June 7, 2013

**Re: Murphy Express, SE San Mateo & Zuni, Traffic Circulation Layout
Engineer's Stamp dated 5-31-13 (L18-D079)**

GRADING AND DRAINAGE PLAN

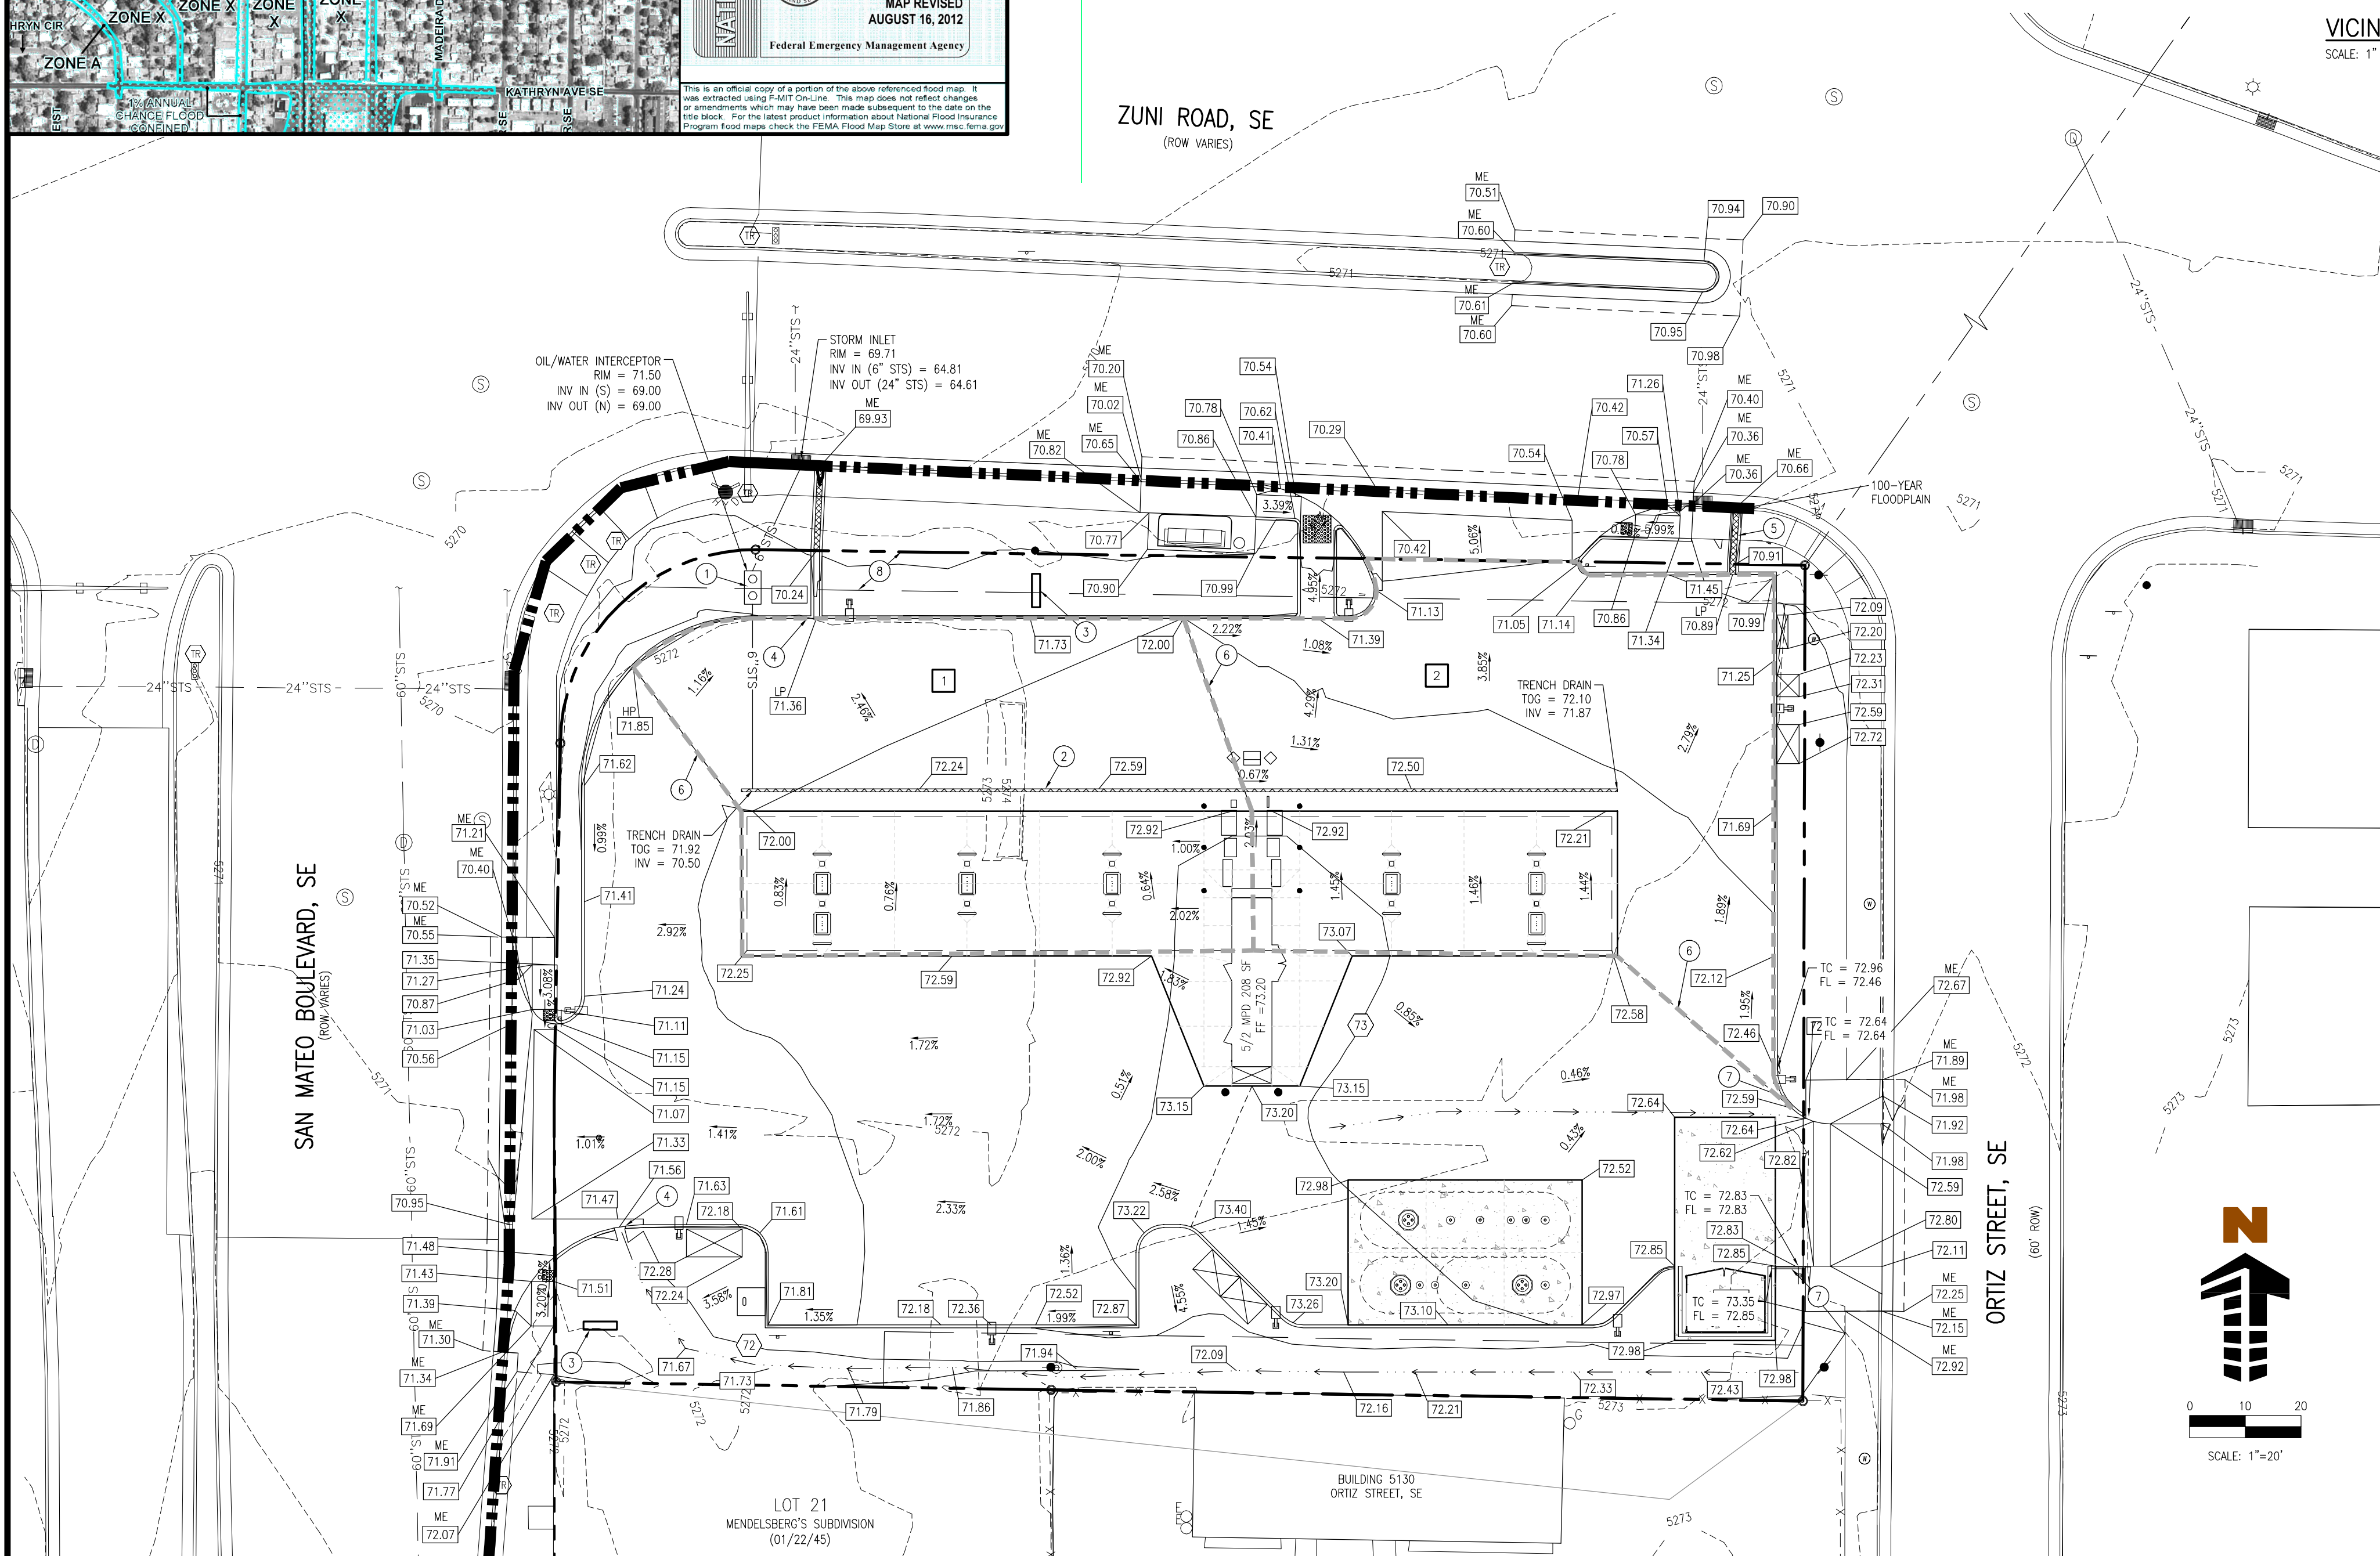
14. An "existing water manhole to remain" keyed note #40 is located within the slope of an ADA sidewalk ramp. This is strongly discouraged. Please move the water meter or adjust the placement of the curb cut with ramp.
15. What is proposed for the unlabeled area between the public sidewalk and the property line at the corner of San Mateo and Zuni. If landscaping is proposed it must not interfere with the sight distance of the intersection. Please add the following note: "Landscaping and signing will not interfere with clear sight requirements. Therefore, signs, walls, trees, and shrubbery between 3 and 8 feet tall (as measured from the gutter pan) will not be acceptable in this area." Please see sight distance exhibit at street intersections for clarification (*Development Process Manual*, Chapter 23, Part B, Section 5.a).

MONUMENT SIGN SECTION
SCALE: 3/4" = 1'-0"

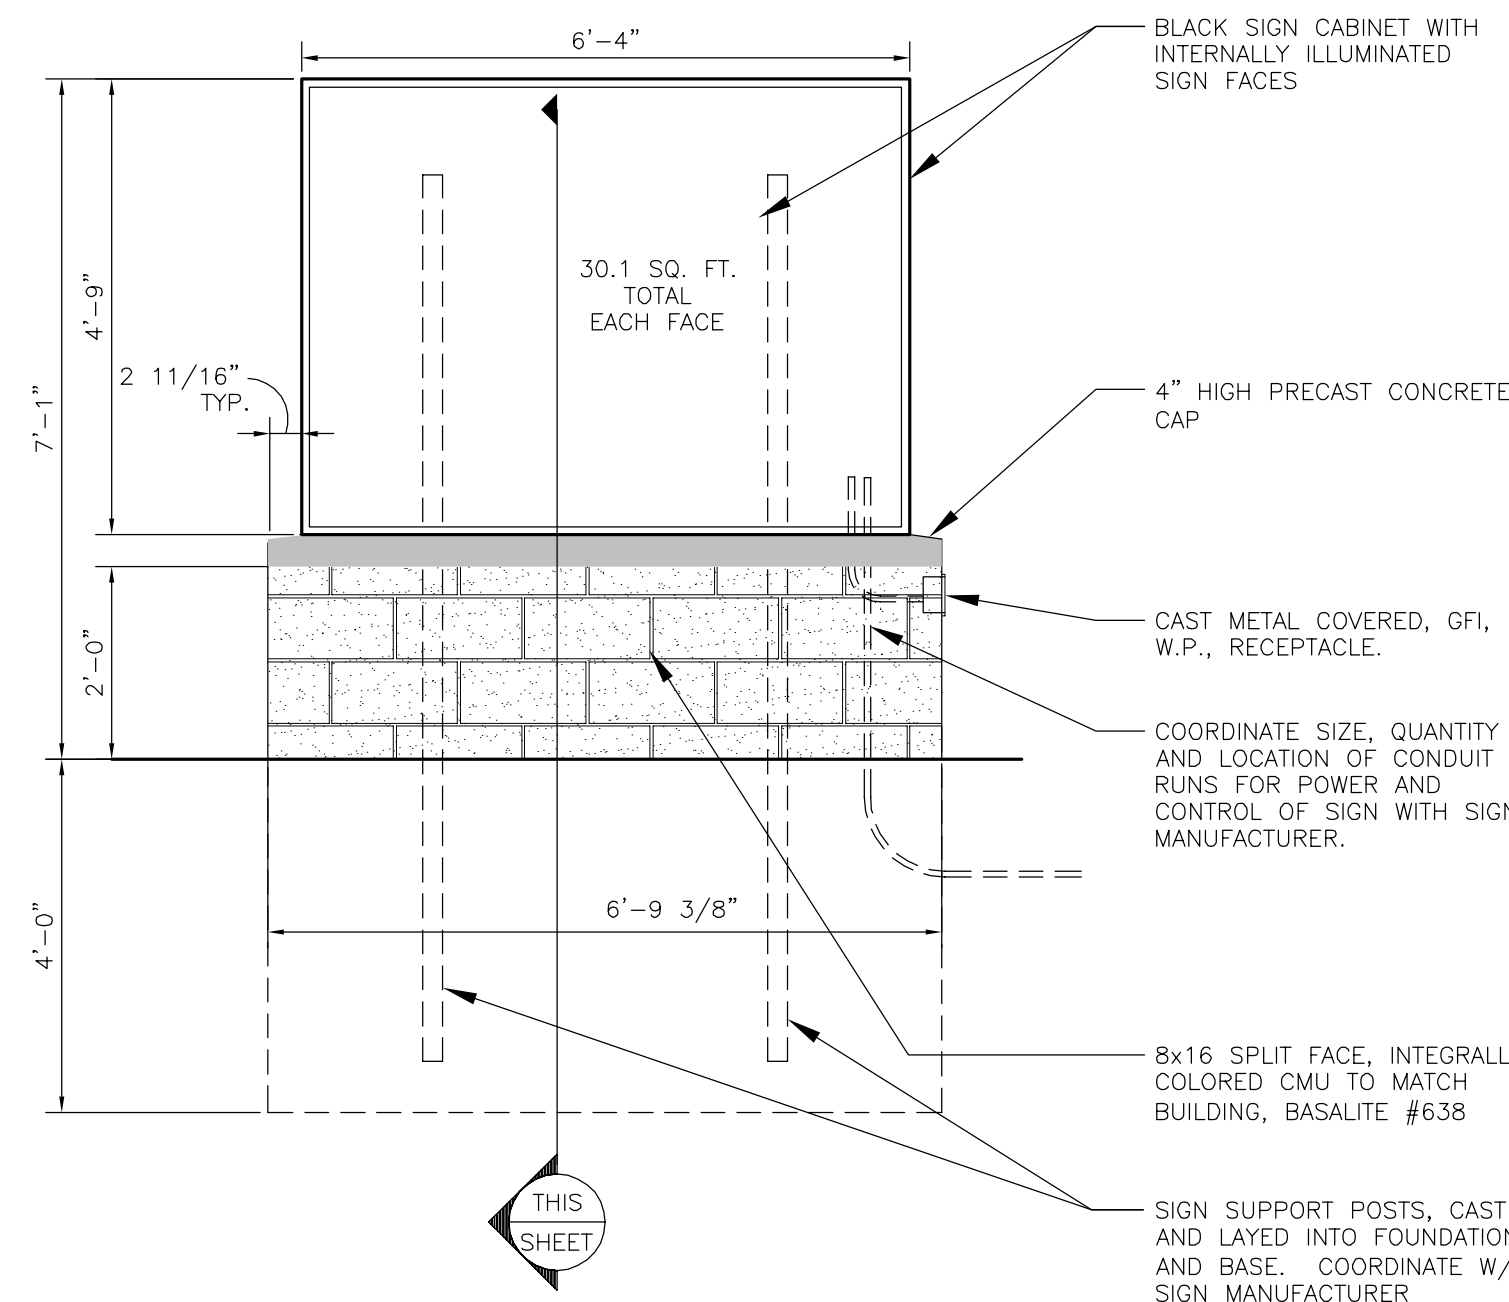
16. Please confirm that the monument sign, landscaping, or any other protuberances do not interfere with the clear sight triangle and sight line distances at the drive pads.
17. Work within the public right of way requires a work order with DRC approved plans. (median nose extension, asphalt saw cuts / patchback and bus shelter).
18. The replat consolidating the six lots into one lot must be recorded prior to Certificate of Occupancy.
